Australian Technology Park Redevelopment SSD 7317

Submission to NSW Planning and Environment
9 March 2016

City of Sydney

June 21 : 10.00am

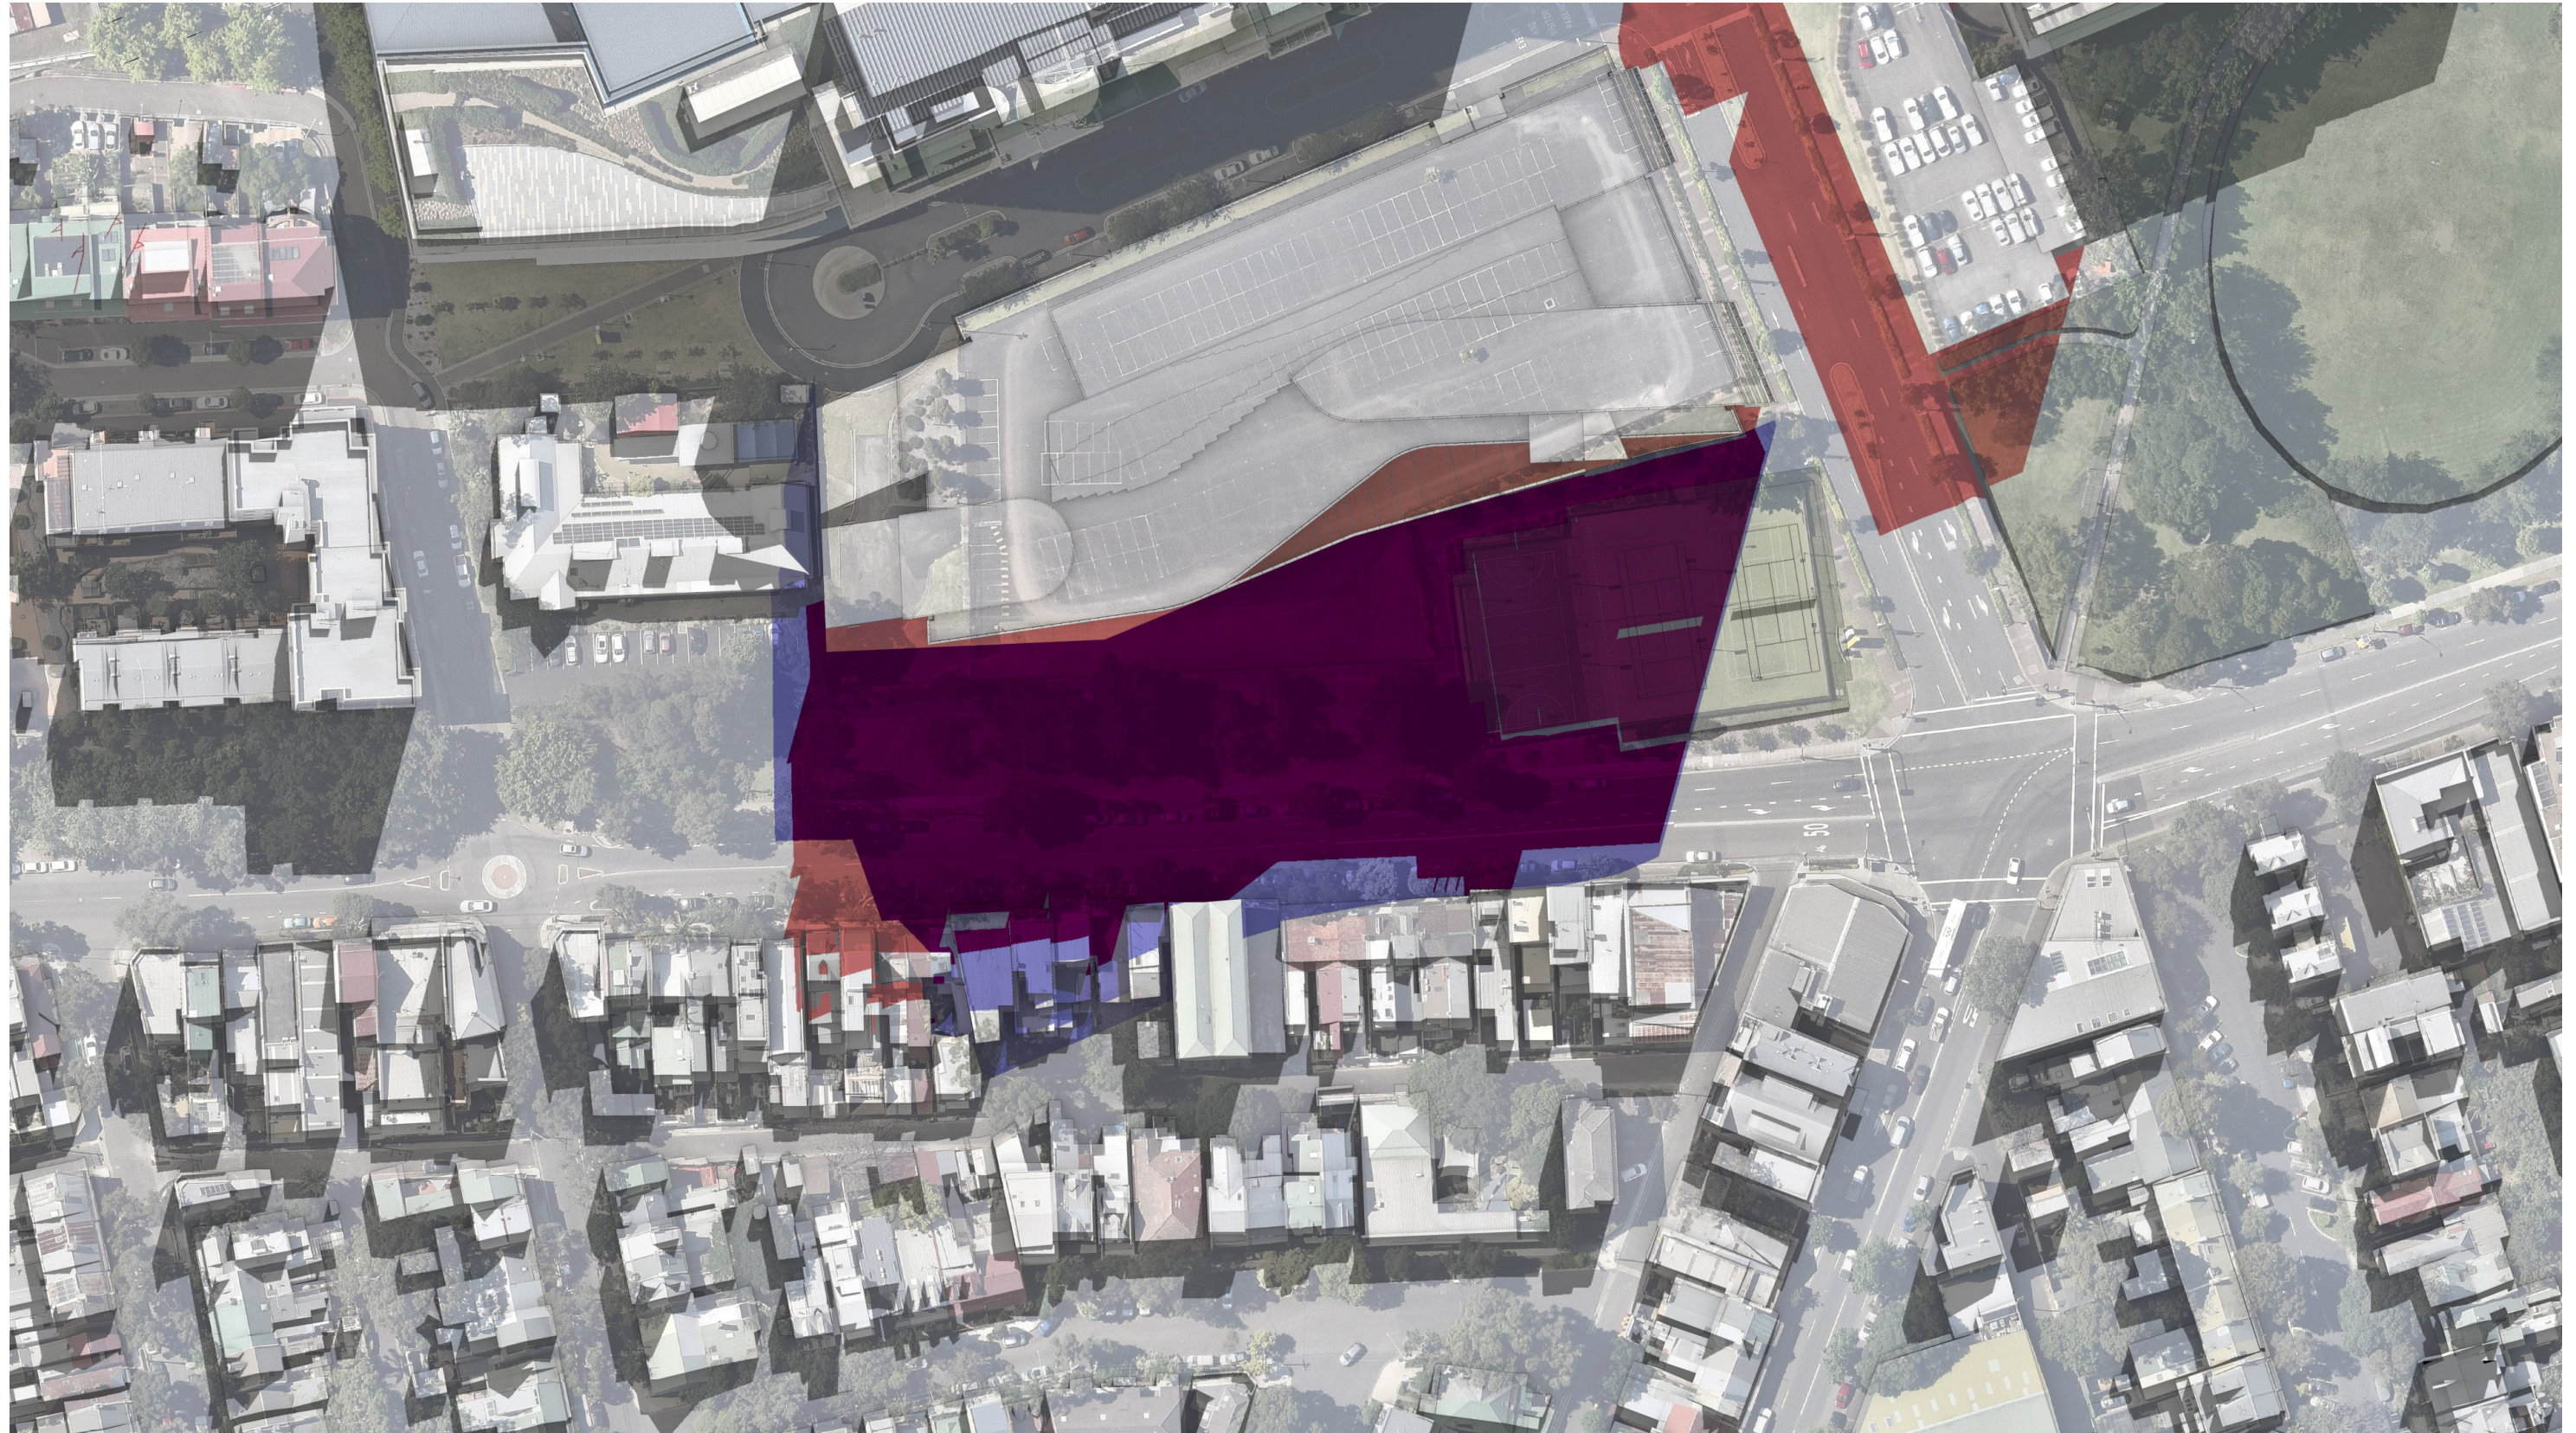
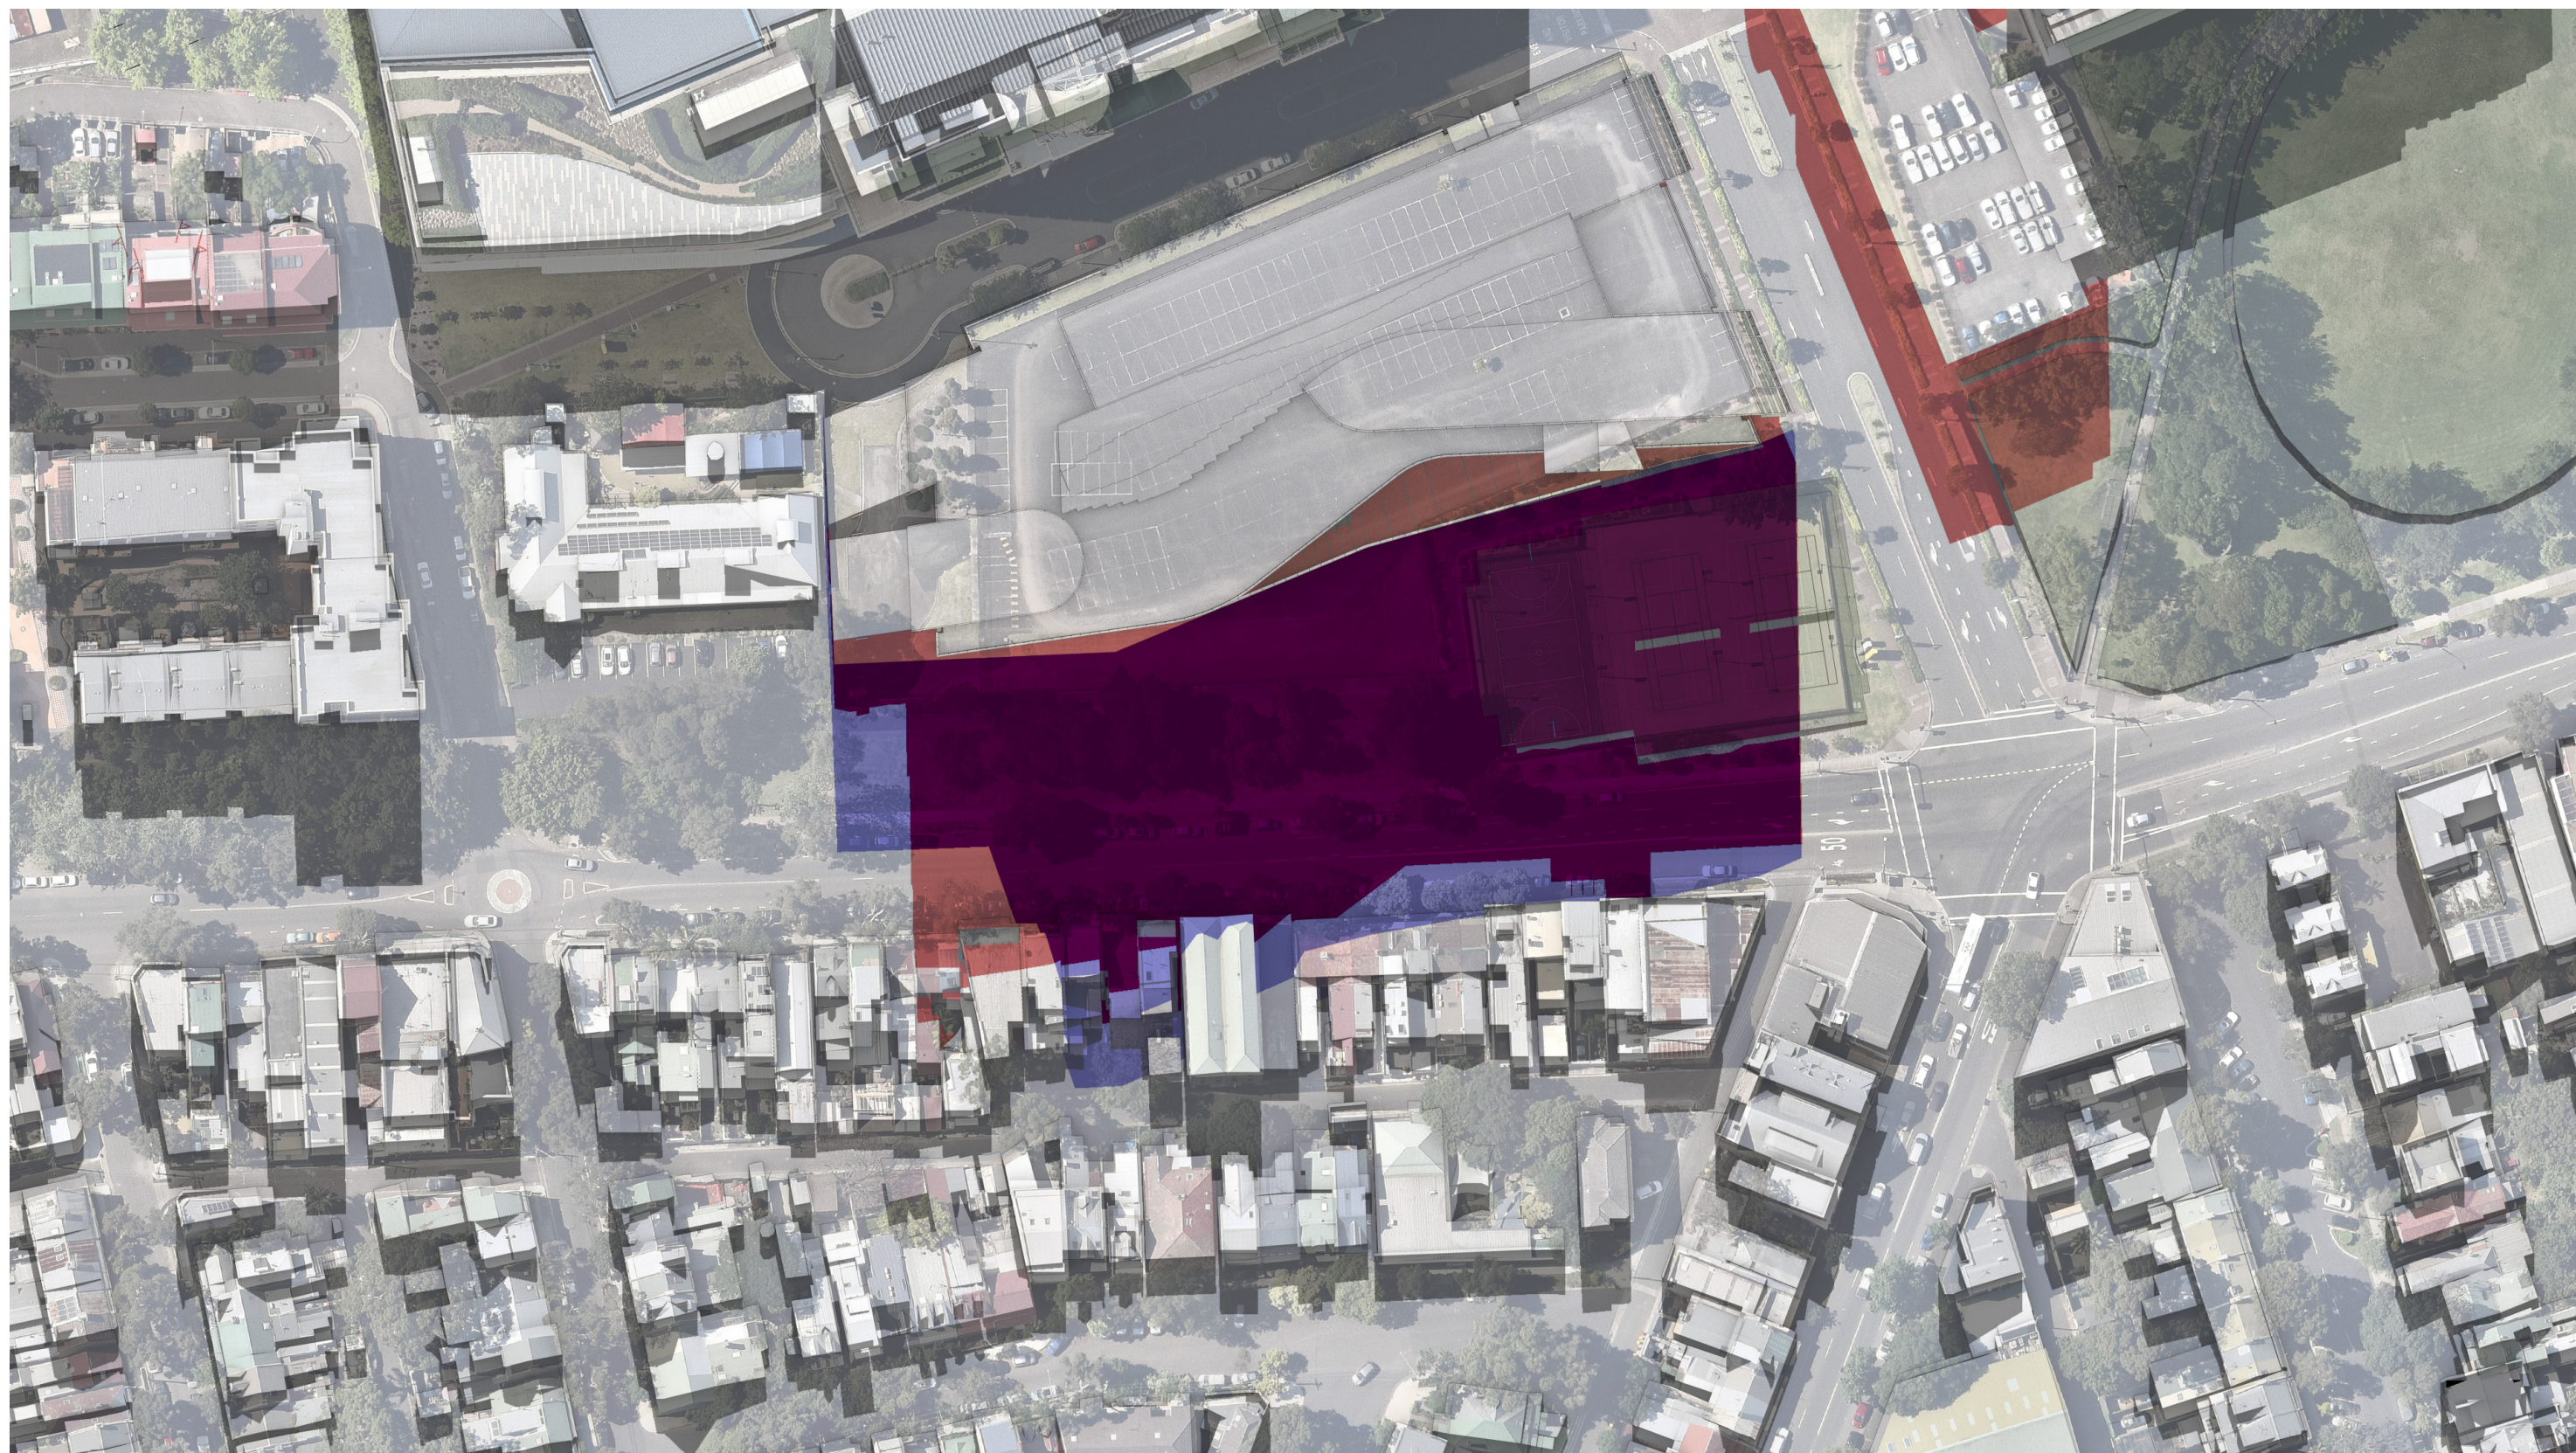
The additional bulk and scale of the building at the western edge results in adverse additional overshadowing of properties along Henderson Road, many of which would not be overshadowed at all with a compliance scheme and many of which would get afternoon relief from overshadowing with a compliant scheme.

The existing 4-storey height control should be stayed and Building 1 height reduced from 9 storeys to 4 storeys by redistribution of GFA to create a more appropriate scale shift to development to the west and reduce overshadowing and visual impacts on surrounding properties to the west and south.
